SSI 22765520 - Sydney Metro West – EIS for Rail Infrastructure, Stations, Precincts and Operations – SOPA Submission

Thank you for the opportunity to review and comment on the Environmental Impact Statement 3 (EIS 3), prepared by Sydney Metro, for rail infrastructure, stations, precincts and operations as referenced above.

ATTACHMENT – SOPA Recommended Conditions of Consent for SSI-22765520 - Metro Stage 3 EIS for Rail Infrastructure, Stations, Precincts and Operations

**Figure 9-11 Primary construction haul routes – Sydney Olympic Park metro station**

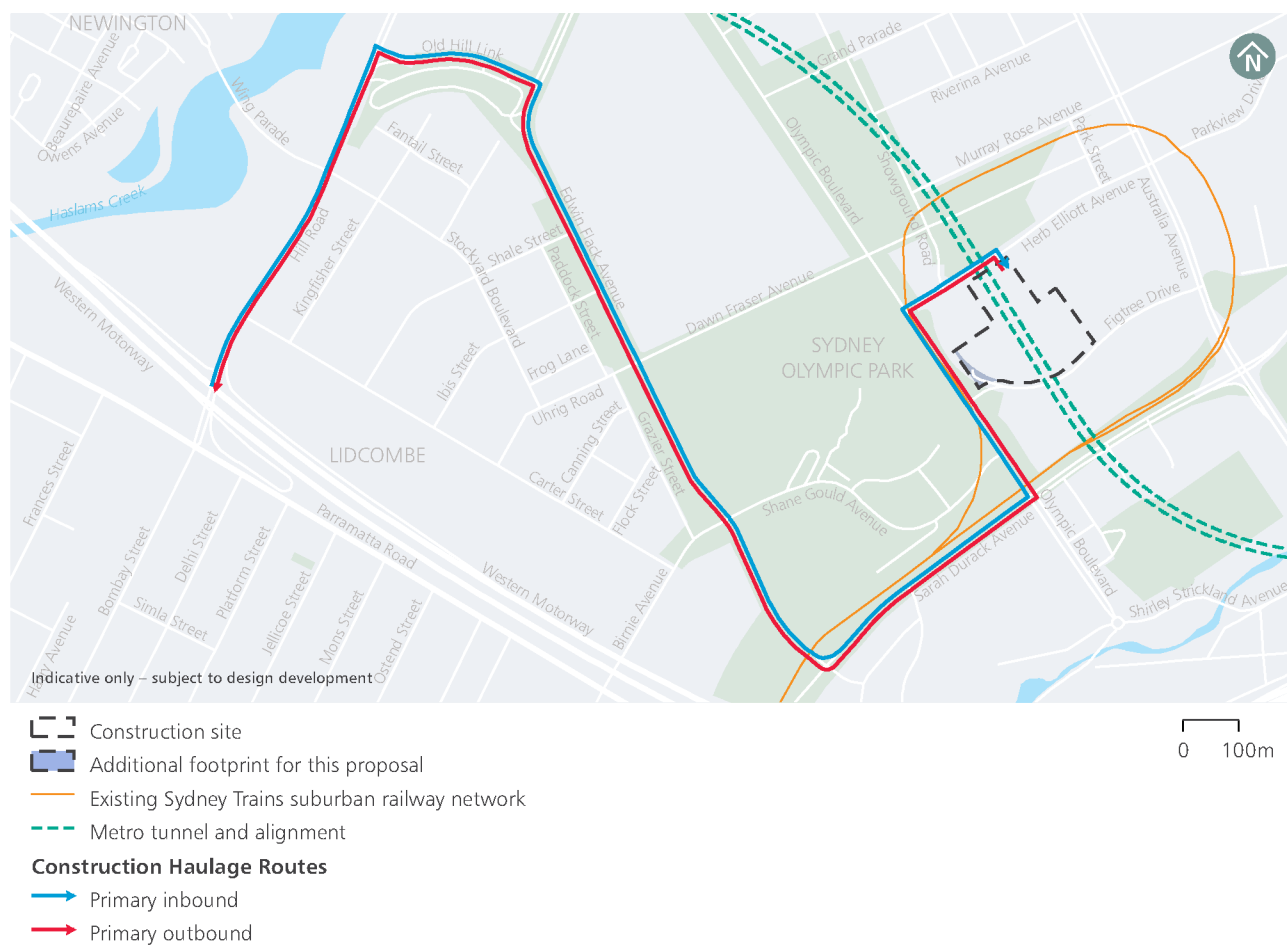
The proposed vehicle construction route in the EIS is not aligned with the approved heavy vehicle route approved under the Traffic Management Plan for Stage 1 Construction (tunnelling and station box) which is already underway. It is critical that this is resolved to protect the amenity of residents at SOP who will experience an extended period of construction and traffic noise.

The heavy vehicle route should reflect the approved construction route already being used. All impacts resulting from this route change need to be reassessed such as traffic impacts and noise and vibration.
